KITTITAS COUNTY COMMUNITY DEVELOPMENT SERVICES

RE: Transmittal of Comments – Hawkins Short Plat (SP-09-00018)

SUBJECT: Hawkins Short Plat SP-09-00018

HAWKINS SHORT PLAT
PART OF SECTION 30, T. 17 N., R. 20 E., W.M.
KITTITAS COUNTY, WASHINGTON

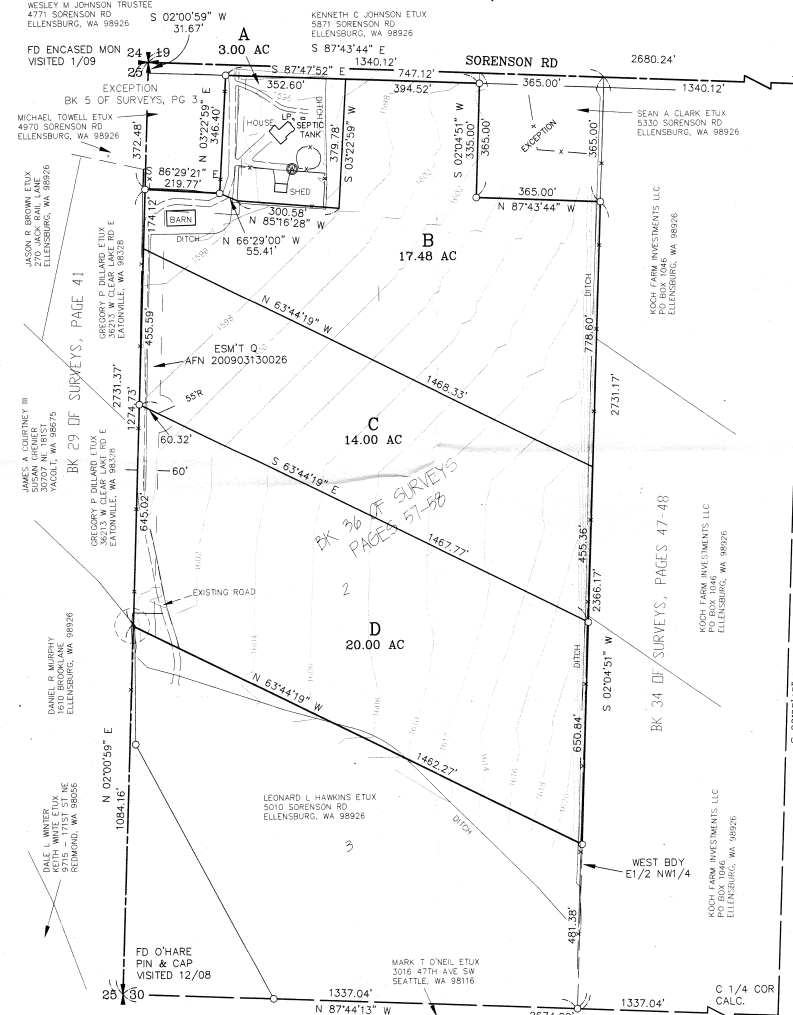
3. Private Road Improvements: Access from Sorenson Road to the cul-de-sac shall be constructed as a Low-Density Private Road. See Kittitas County Road Standards, 9/6/05 edition.

- a. Access easements shall be a minimum of 60' wide. The roadway shall have a minimum width of 20', with 1' shoulders, for a total width of 22'.
 - b. Minimum centerline radius will be 60'.

- c. The surface requirement is for a minimum gravel surface depth of 6".
 - d. Maximum grade is 12%.
 - e. Stopping site distance, reference AASHTO.
 - f. Entering site distance, reference AASHTO.

- j. All easements shall provide for AASHTO radius at the intersection of county road.
 - k. A paved apron shall be constructed at the intersection of the proposed private intersection and the county road right of way.

4. Cul-de-Sac: A cul-de-sac turn-around having an outside right-of-way or easement diameter of at least 110 feet shall be constructed at the closed end of all dead-end roads serving 3 or more lots. The driving surface shall be at least 96 feet in diameter. Cul-de-sacs must also conform to the requirements specified by the 2006 International Fire Code. Contact the Fire Marshal regarding any additional cul-de-sac requirements.
